# CITY OF ALBUQUERQUE

**RE: 3601 Seven Bar Loop Rd NW**  
**Grading and Drainage Plan**  
**Engineer's Stamp Date: 02/26/2026**  
**Hydrology File: B14D019**  
**Case # HYDR-2026-00074**

Based upon the information provided in your submittal received 02/27/2026, the Grading and Drainage Plan **is not approved** for Grading Permit and Building Permit. The following comments need to be addressed for approval of the above referenced project.

DRAWN BY BF
DATE 03/18/2026
2024014_BASINS
SHEET # GR-0
JOB # 2024014

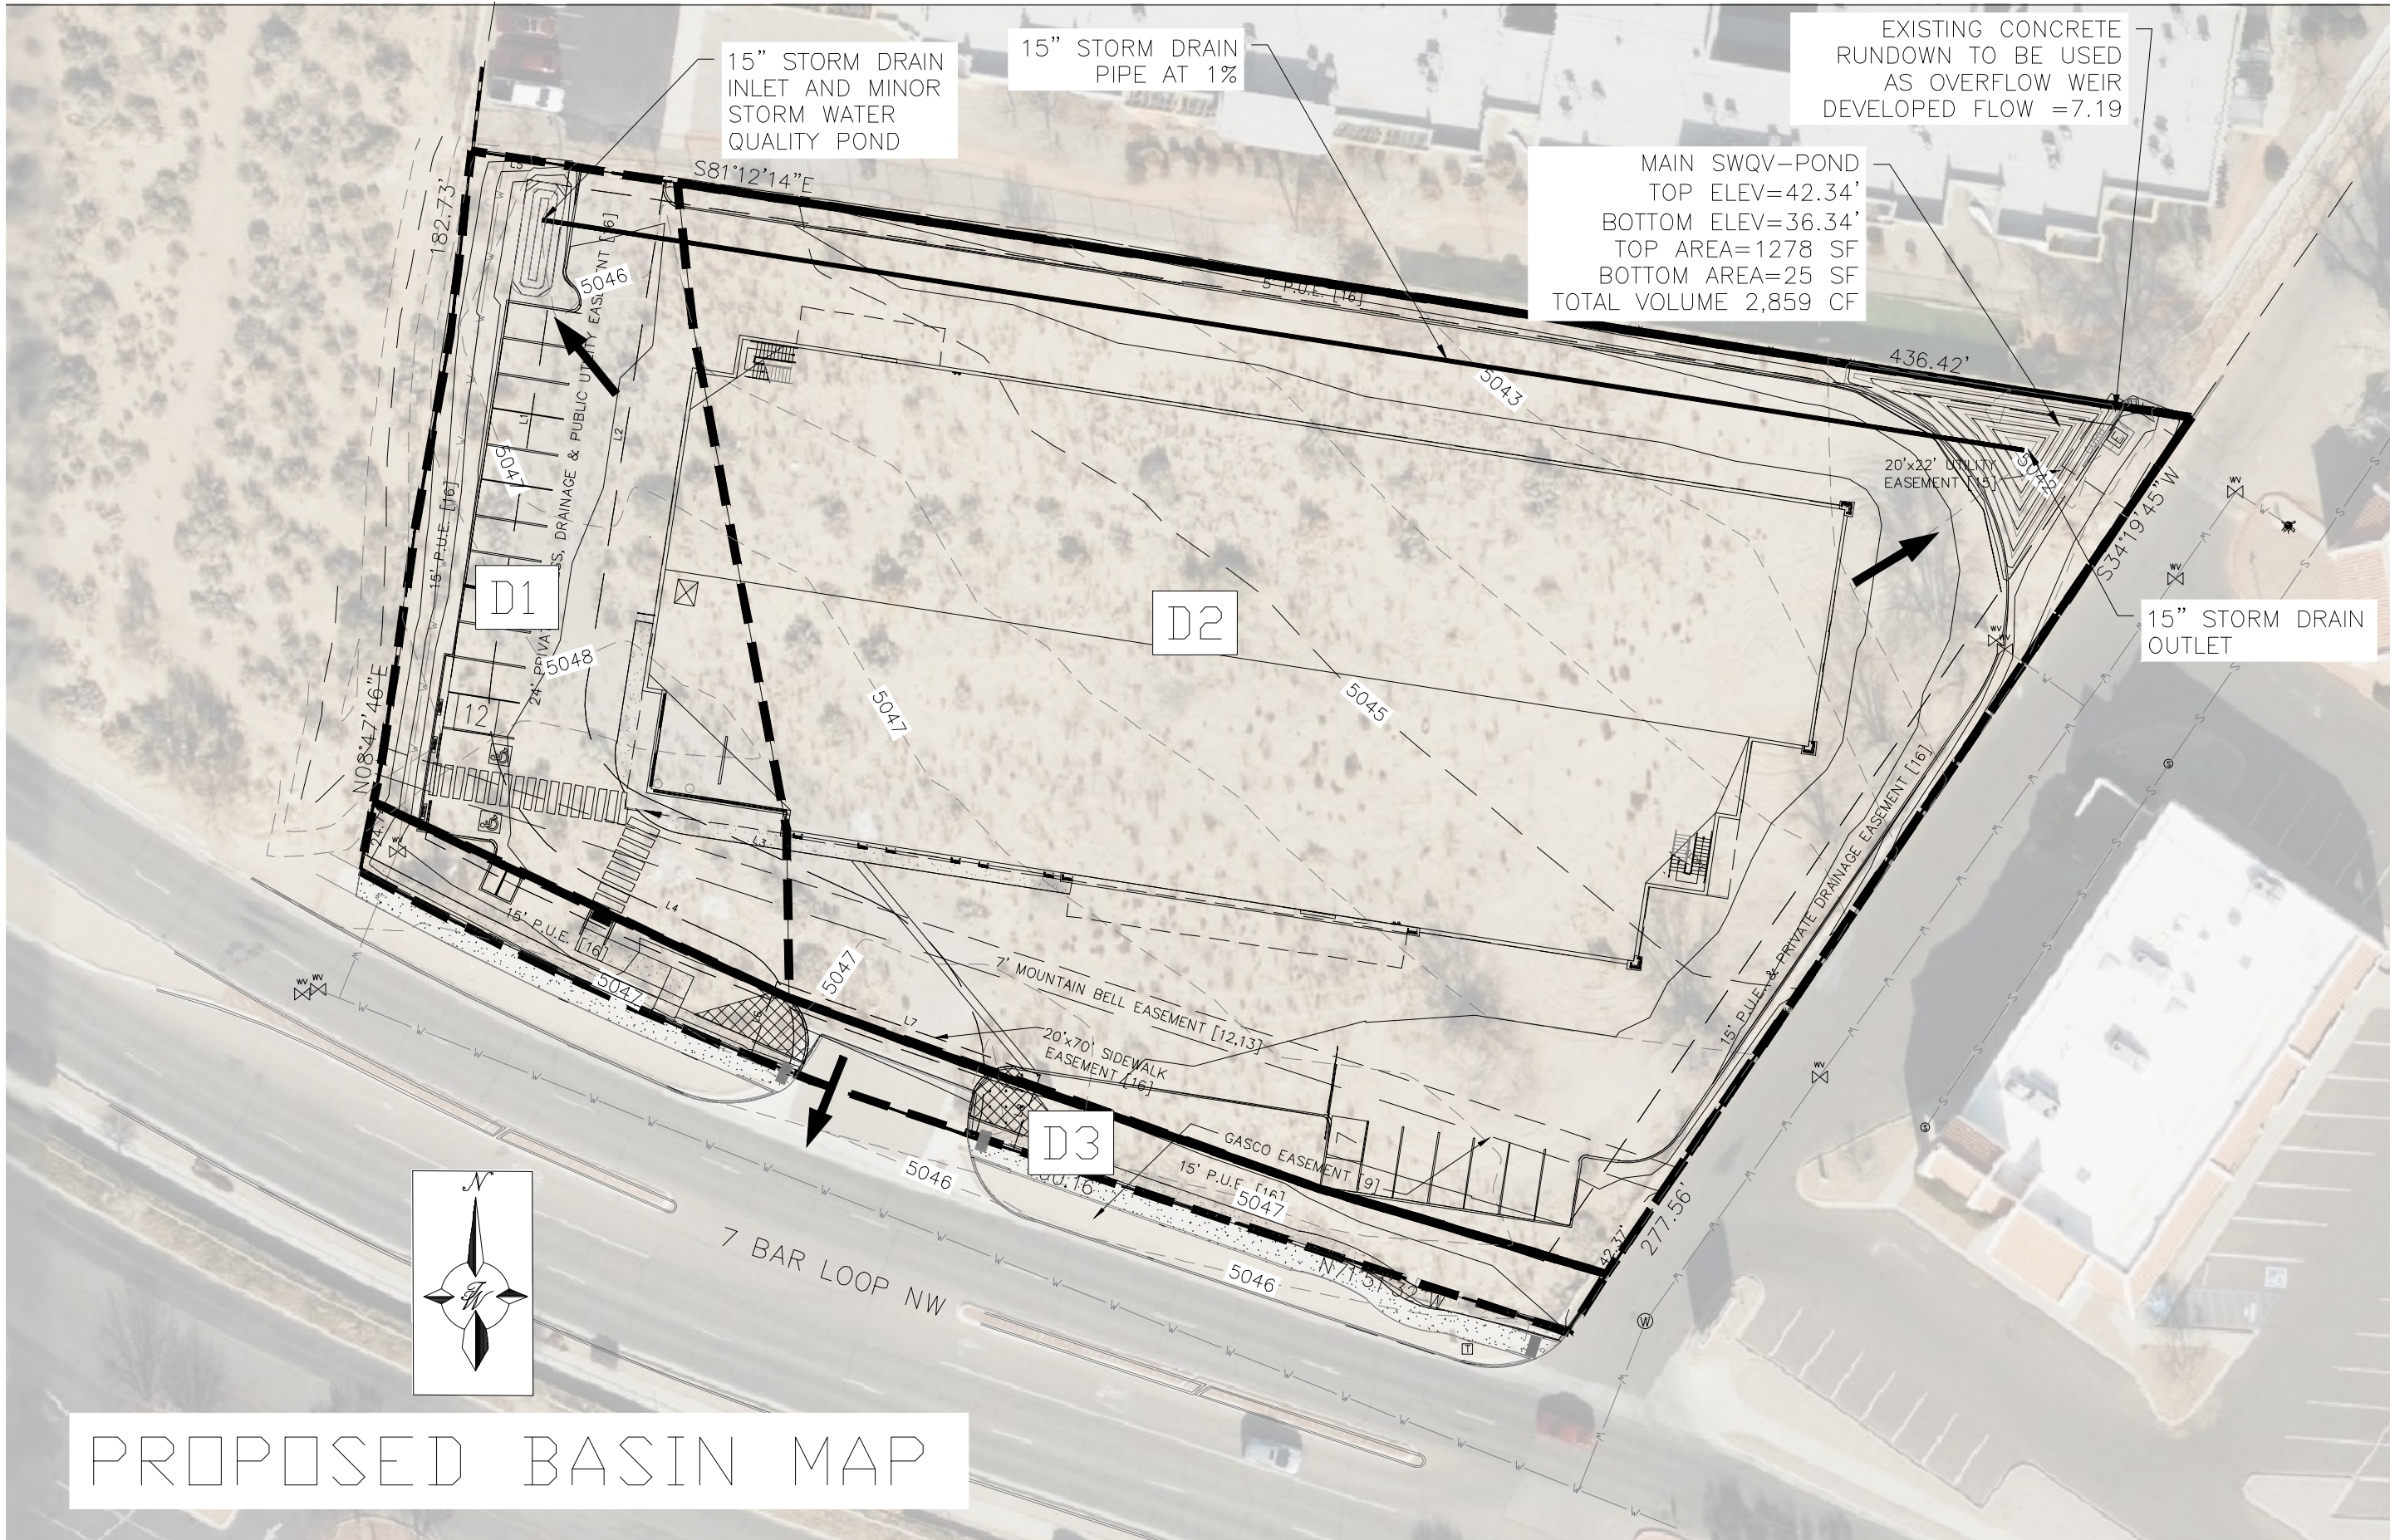
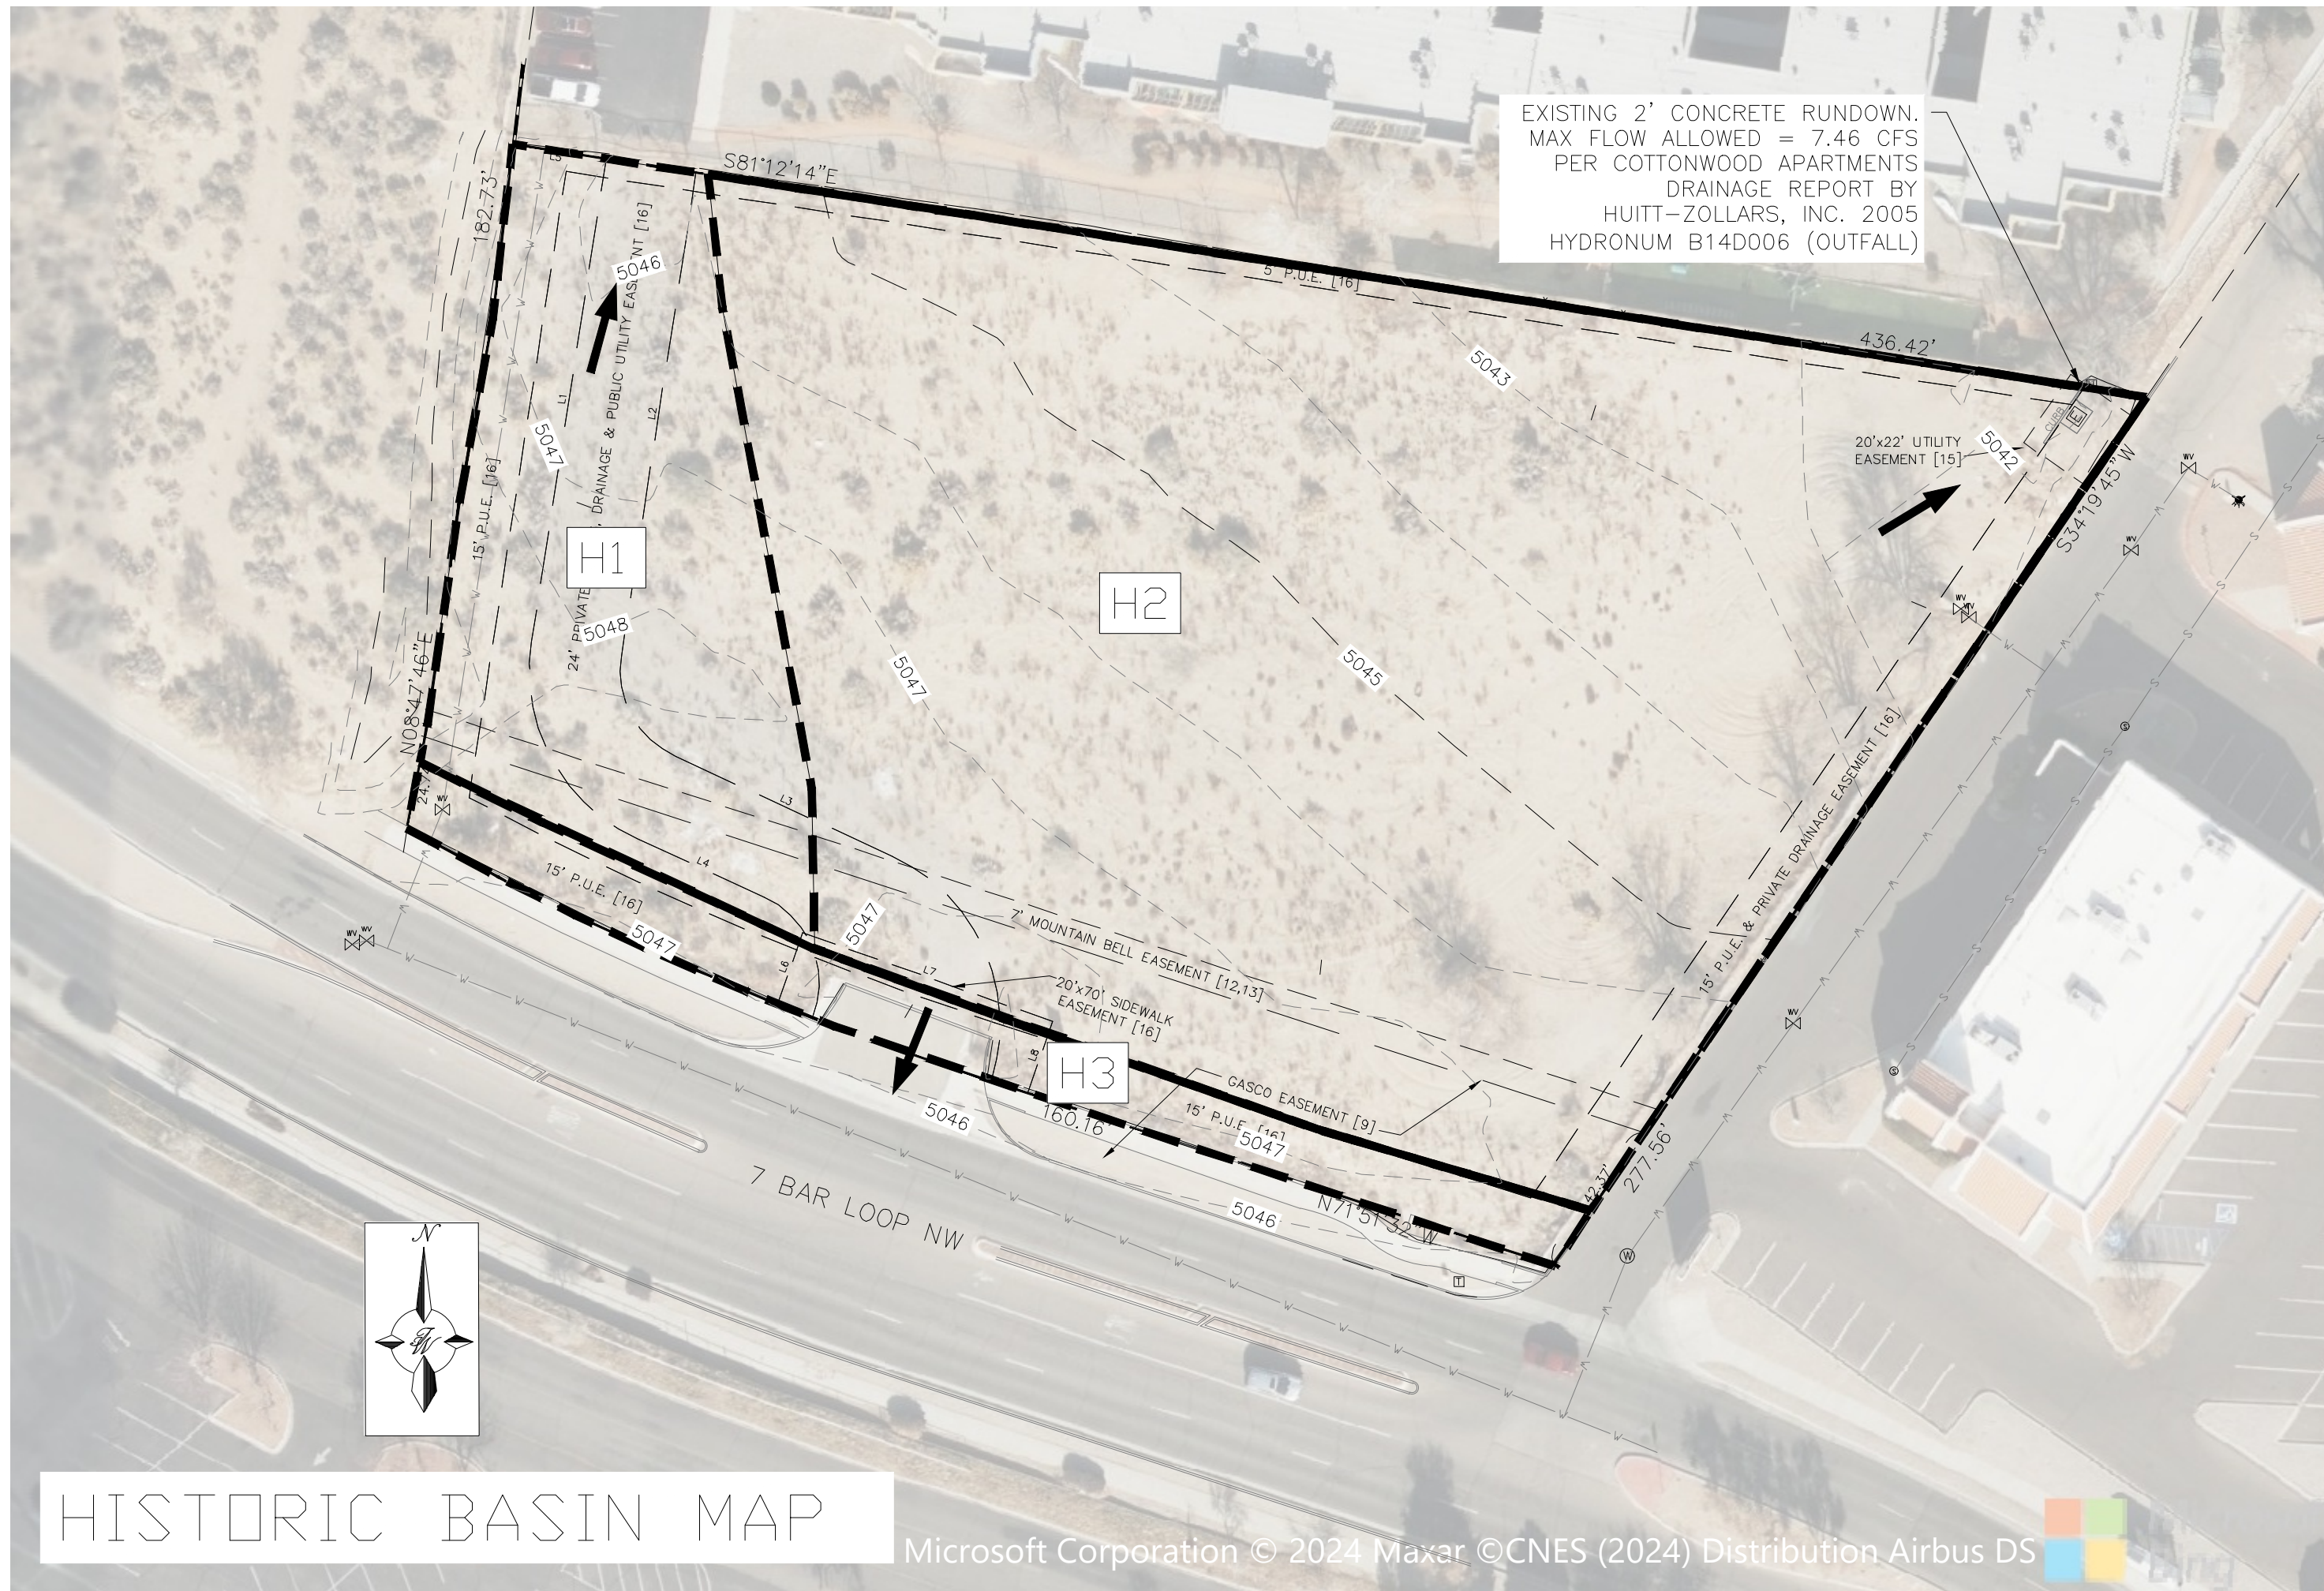
1. Please provide the legal description of the property.
2. Please provide the Benchmark information (location, description and elevation) for the survey contour information provided.
3. Show finished floor and finished pad elevations for all structures.
4. Please make sure treatment areas add up to 100%
